Subject: Nyton Nursery Application AL/102/17/RES

Further to our telephone conversation we are very concerned regarding the detailed landscaping proposals that have now been submitted. As you can see from the attached drawings, our property Jacaranda is adjacent to the site and the house is situated very close to the boundary. Our living room is on the first floor overlooking the site as is one of our bedrooms and our kitchen and dining room are on the ground floor. All these rooms have windows facing on to what is proposed to be a children's play area and cycle path. The cycle path is proposed to run immediately on the other side of our fence which will be within 2m of our house.

Drawing Number 102 Rev A

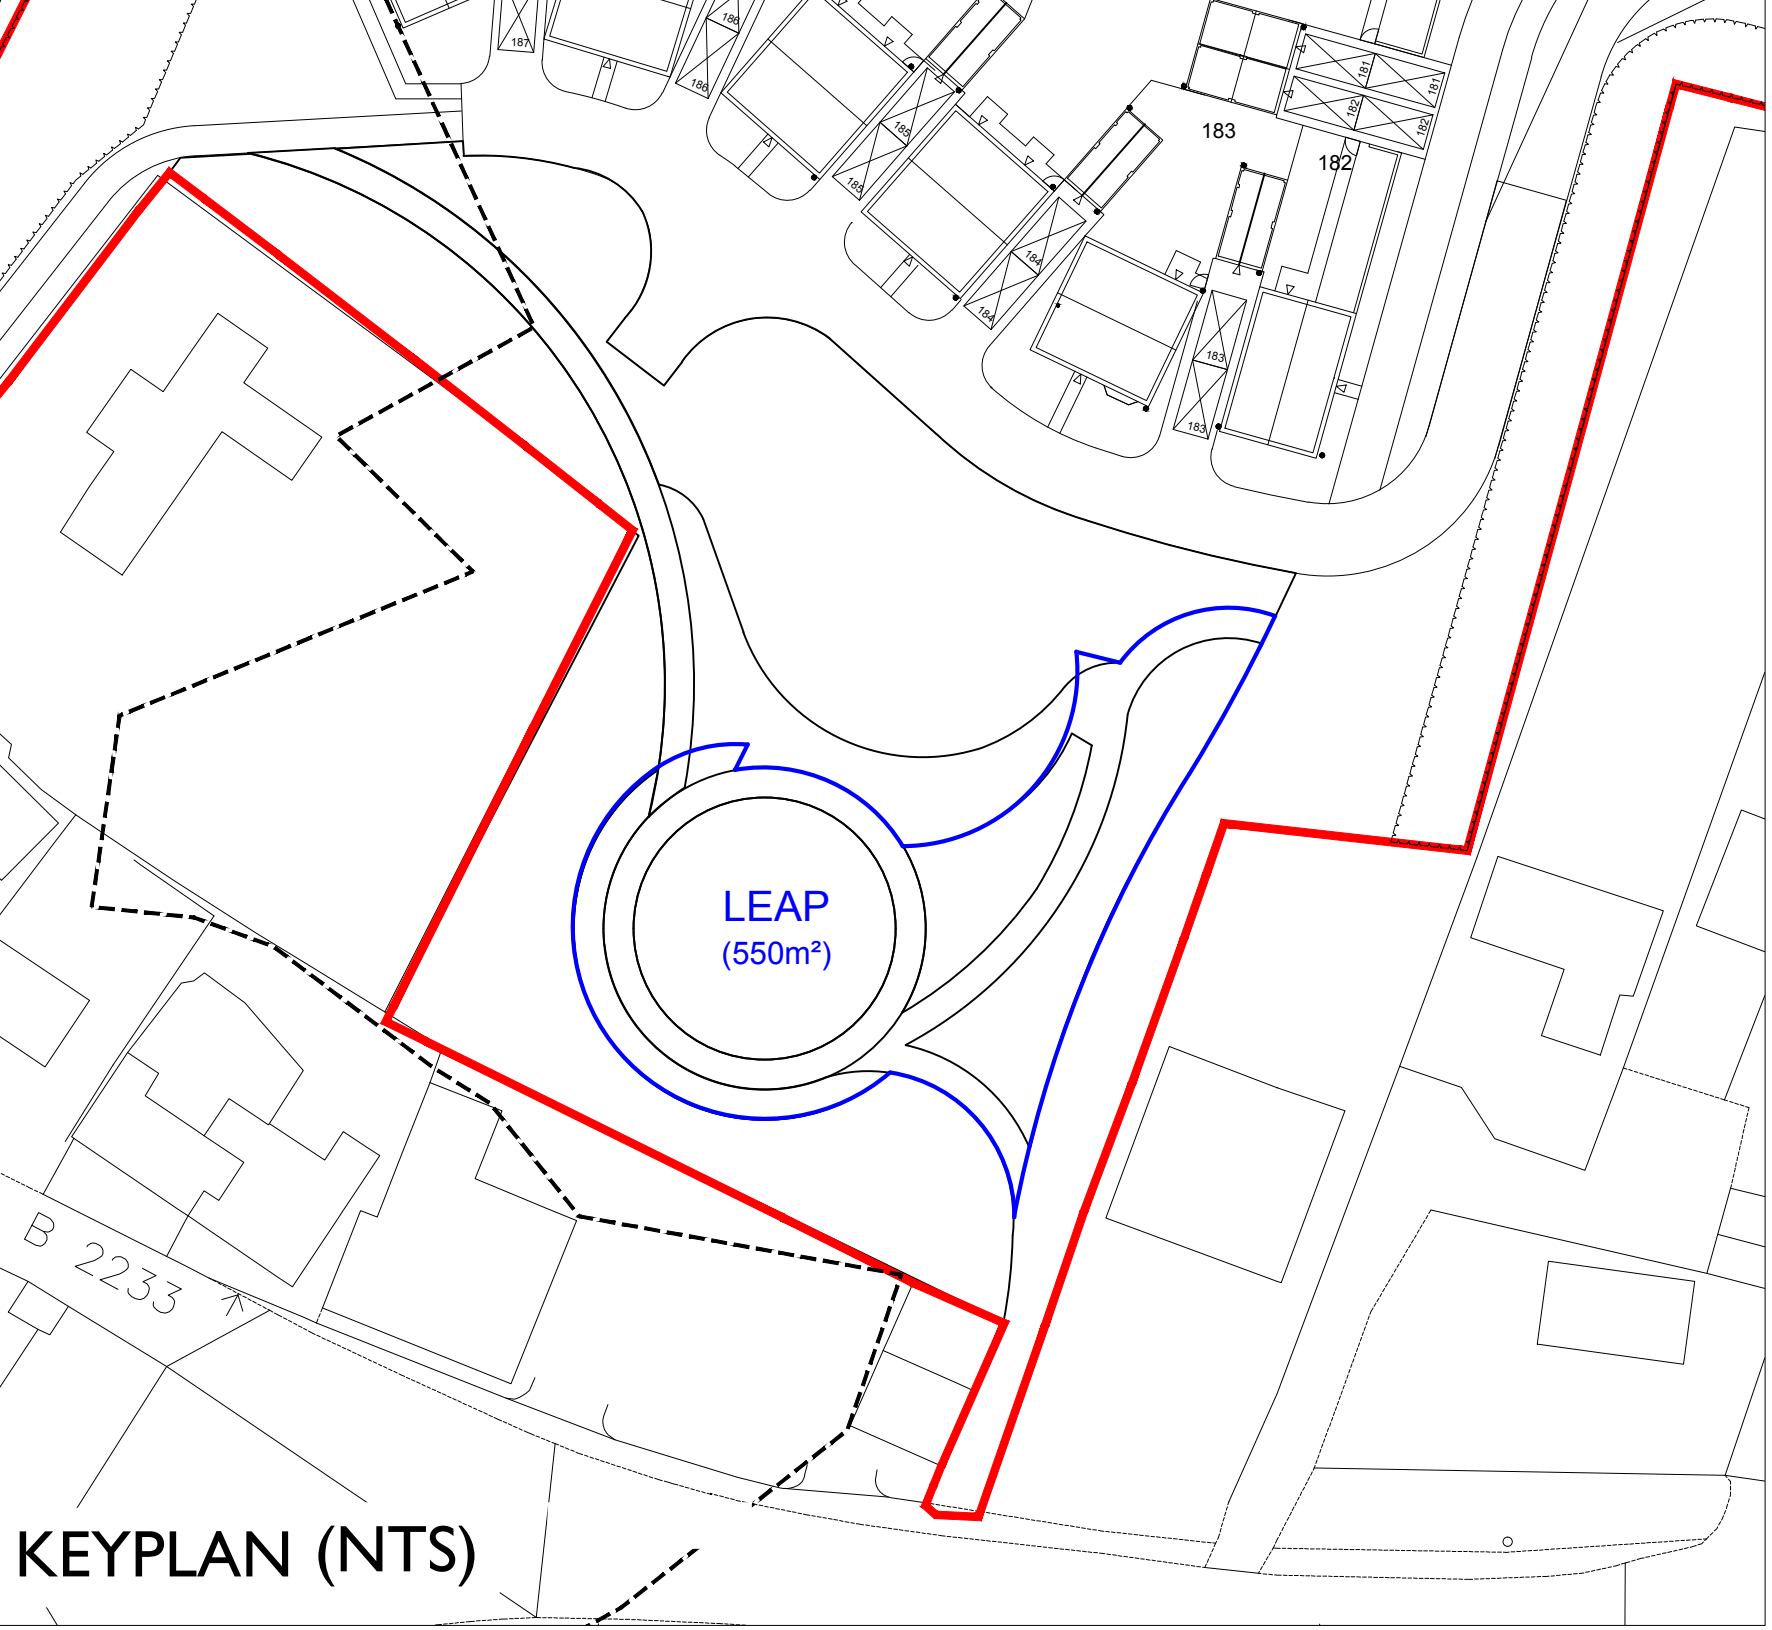
From looking at the landscaping plans for the whole development it would appear that all other existing houses bordering onto the proposed site are well screened with new or existing planting. Our property however, is going to be completely exposed with nearly all the very mature trees and shrubs being removed. We currently enjoy facing on to a natural wooded landscape and are well screened from the A29. If these plans are approved, then our quality of life will be significantly reduced. We will have to suffer the noise of the play area, cyclists and pedestrians walking close to our house and being able to see into our rooms and we will be greatly exposed to the noise and traffic pollution from the A29. These kinds of play areas like the one in Lime Avenue often attract teenagers after dark and we are concerned that as the proposed layout has no passive surveillance (except from us) it will encourage anti-social behaviour.

We appreciate that these play areas have to be provided and that the footpaths are needed, however we do not feel that enough consideration has been given to how our quality of life will suffer. We have tried on many occasions to meet the developer, but they will not meet us to discuss our concerns. I have attached to this email a sketch that I have prepared that demonstrates how the play area and cycle way could be provided whilst at the same time retaining many of the existing trees so that there can be a landscaped buffer that will give us a bit of protection. We would also like some reassurances that lighting will be prohibited along our western boundary as these lights will shine either into our bedroom and living room if they are tall or into our kitchen and dining room if they are low level.

Drawing Number	Rev
712	D

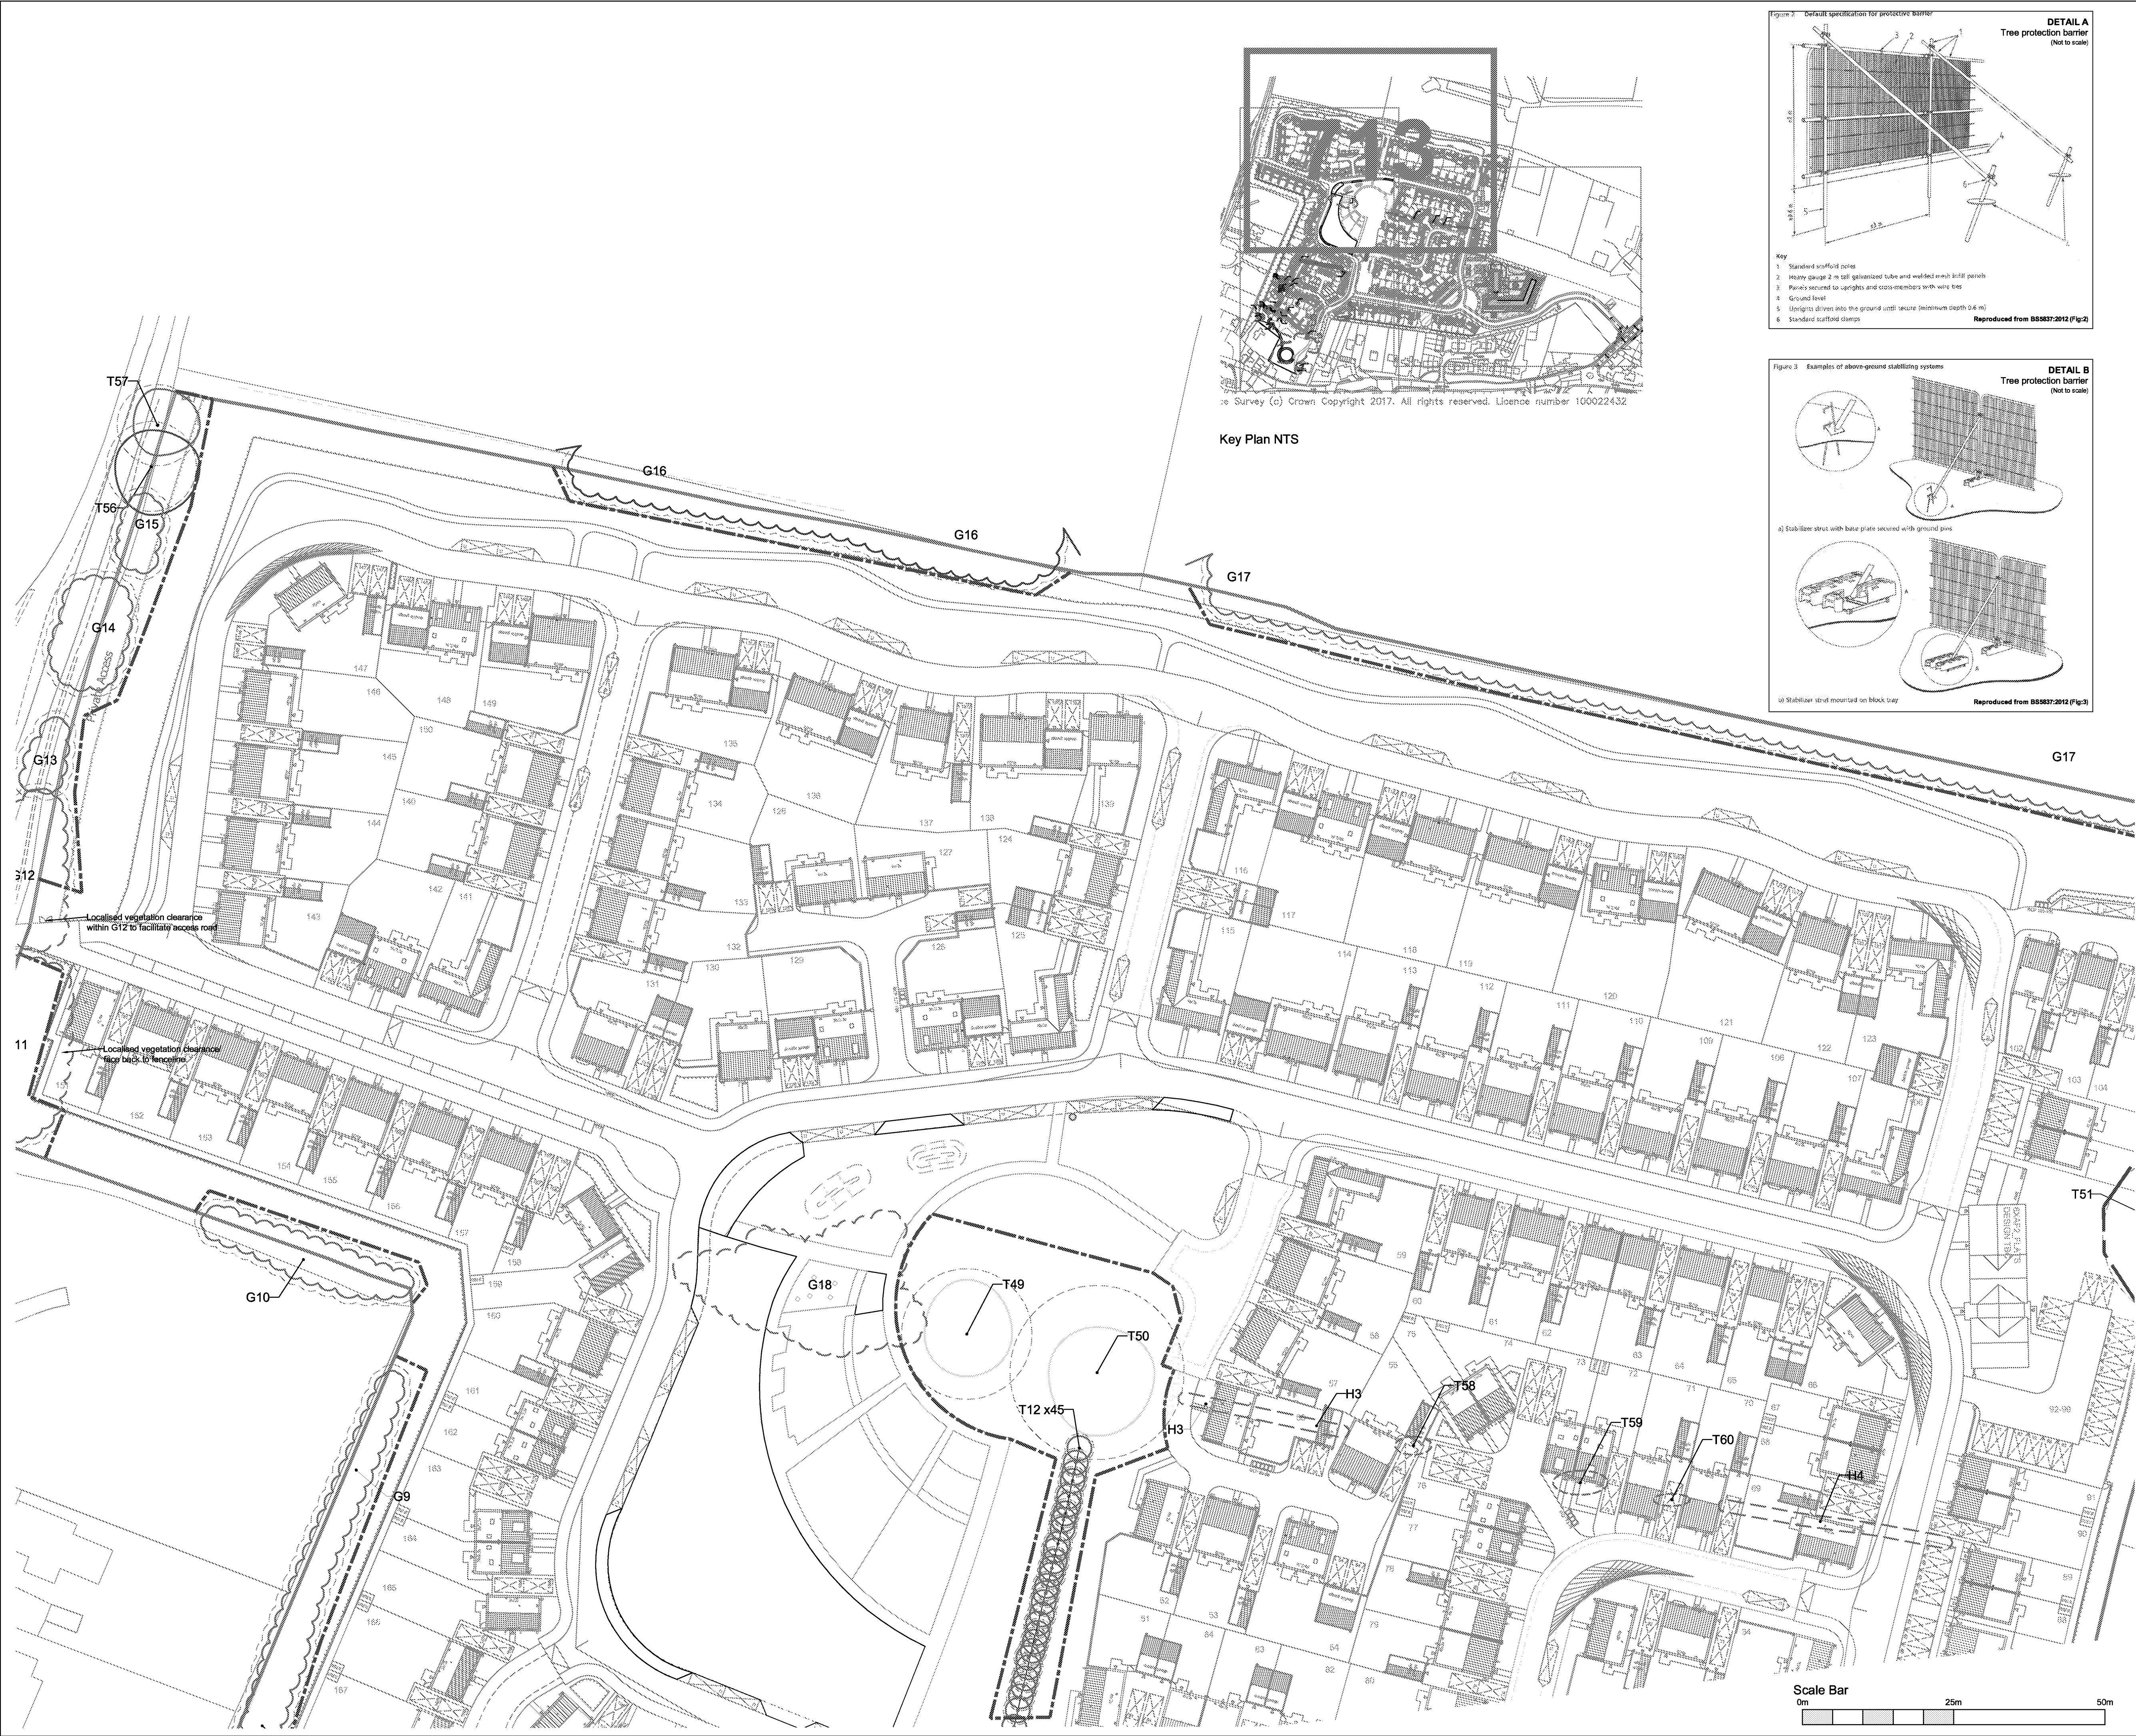
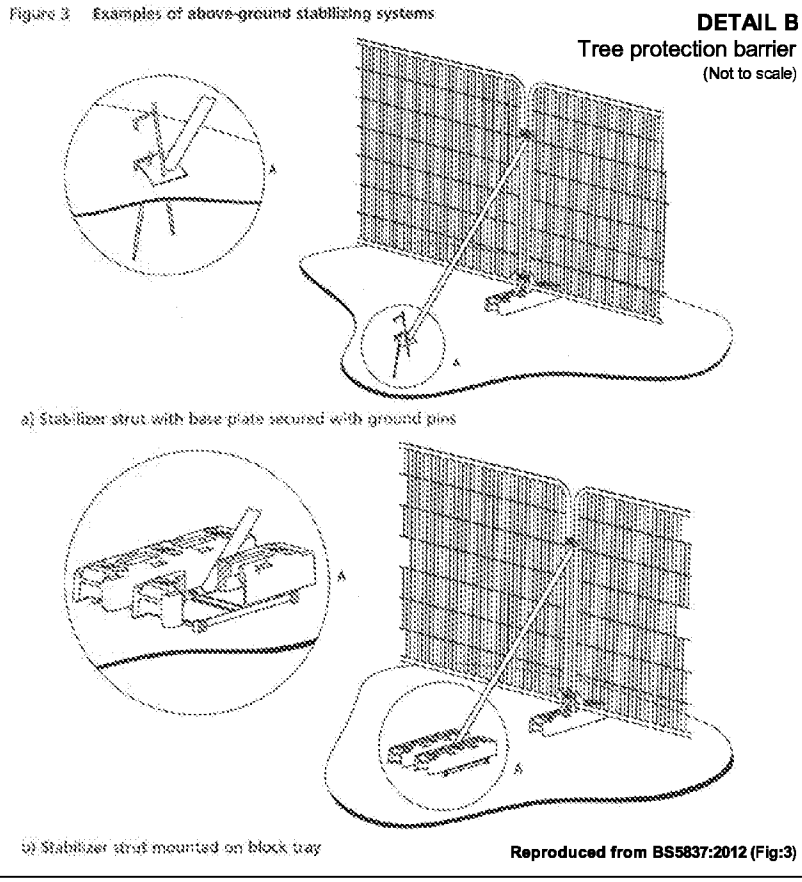
Another matter which is also of great concern to us is the proposal to remove some trees that are protected by Tree Preservation Orders. These trees are significant features in the village and the Holm Oak in particular is very special. Westergate used to have many of these trees and this is one of the last ones remaining. The Oak and Ash trees (T15, T17, T18 and T19) are acknowledged by the Arboricultural Consultant in the Tree Survey as being fine specimens with many years life in them. The only reason that the developer is planning to remove them is to put in the cycle route, which we strongly object to in this location and feel that it could be adequately provided along the access further to the west. A footpath could easily be accommodated whilst retaining these beautiful trees. There are other fine trees such as willows, hawthorns, elders etc that are also being proposed to be removed and whilst they are not as attractive visually do still provide valuable habitat to wildlife. On summer evenings we see bats flying around our garden, which we are sure will now be lost. We understood that the Tree Preservation Order covered more than just tree T15 and we hope that any application to remove these trees will be rejected.
